Address: The Cottage, 2 Daw Knowle Huddersfield hd5 0dr

Application number: 2021/91506	
What is the application for?:	Reserved matters application pursuant to outline permission 2014/92535 for erect
Address of the site or building:	Shop Lane, Kirkheaton, Huddersfield, HD5 0DB
Postcode:	BD8 9TF

Type of comment: An objection	
Do you wish your comments to be published on the website anonymously?	No

**SHOP LANE**

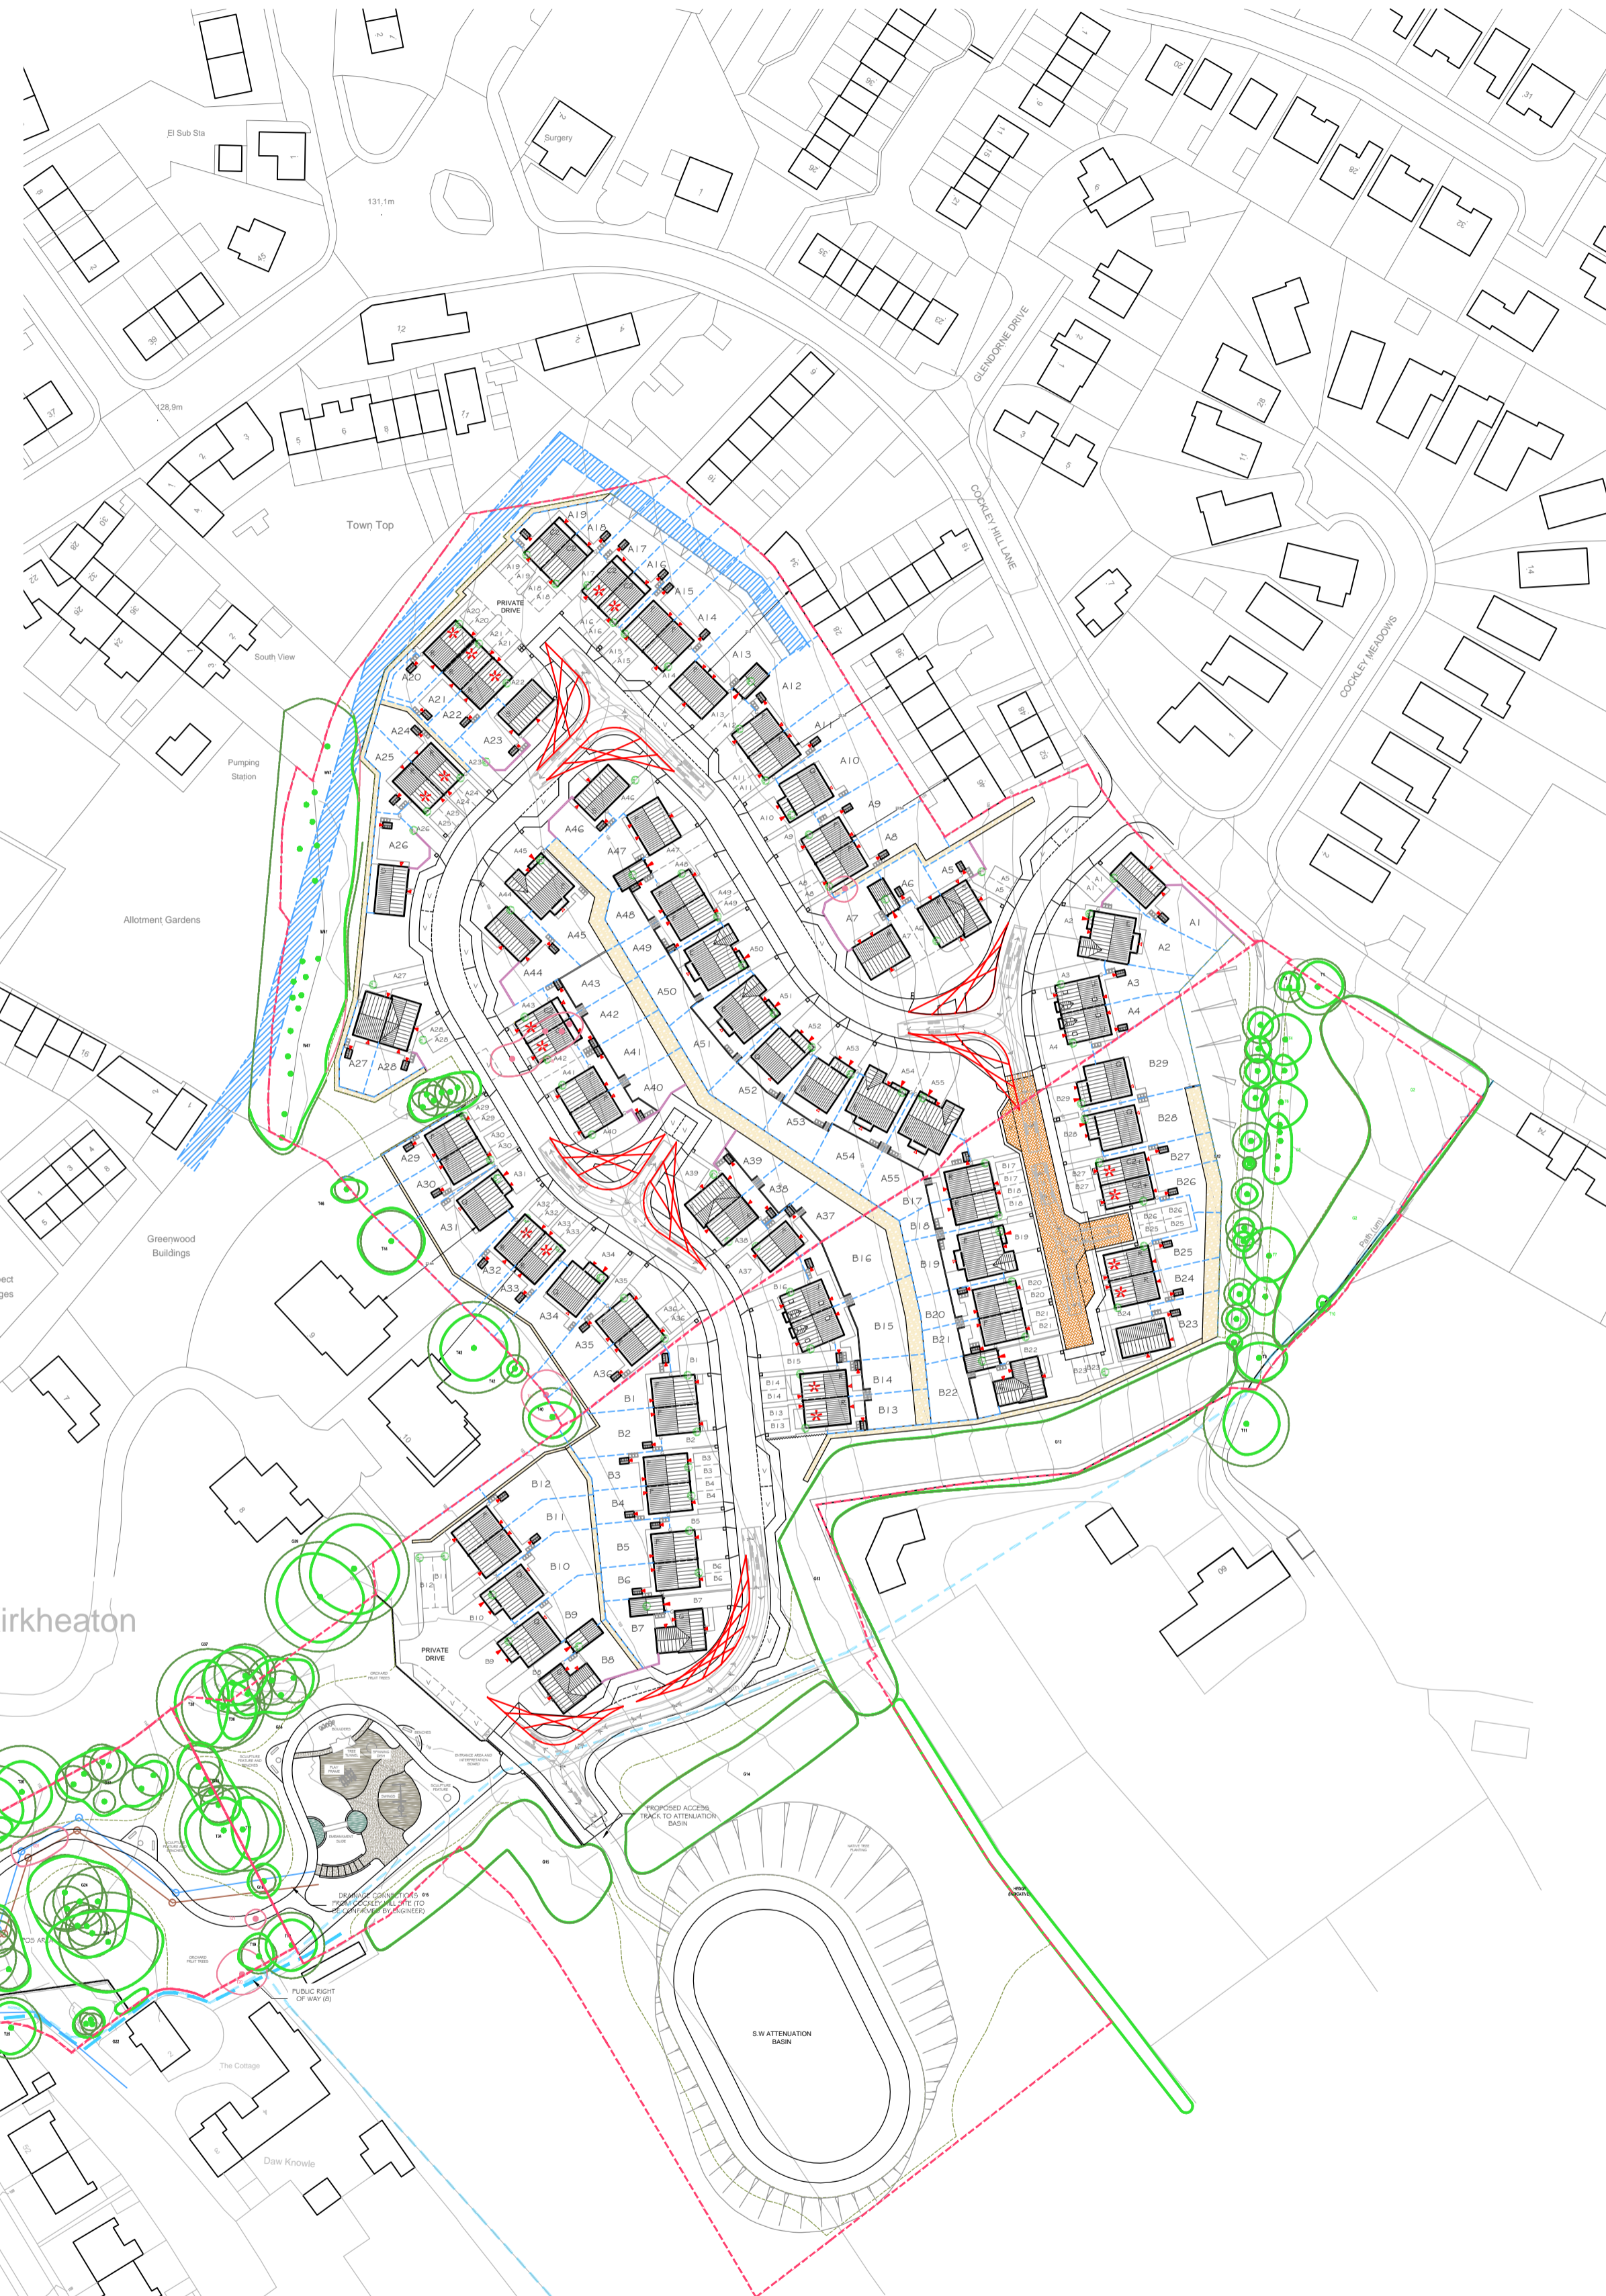
According to the plans submitted, the entrance to Daw Knowle appears to be being widened to a two lane road. Looking at the plans, it does not look as though the proposed developers own the piece of land on Orchard Road, [between Shop Lane and Daw Knowle] part of which is being utilised to widen the road [where cars currently park]. Who owns this piece of land and has permission been given for some of this land to be used? Is this to remain a private road, or is the Council to adopt the same?

Also, the widening of the entrance to Daw Knowle will bring this road much closer to the main road [Shop Lane] which is already very close when taking into account the bus lane into the bus shelter also encroaches onto Orchard Road.

Entering onto Orchard Road and then turning immediately in Daw Knowle is dangerous enough as it is, without moving the entrance even closer to the main road and is likely to cause further accidents. Do the current plans satisfy the distances requirements between a side road leading off a main road?

Again, according to the plans submitted, access to the existing properties on Daw Knowle is no longer accessible. This now appears to be a landscaped area! Clearly the development cannot proceed based on the current plans.
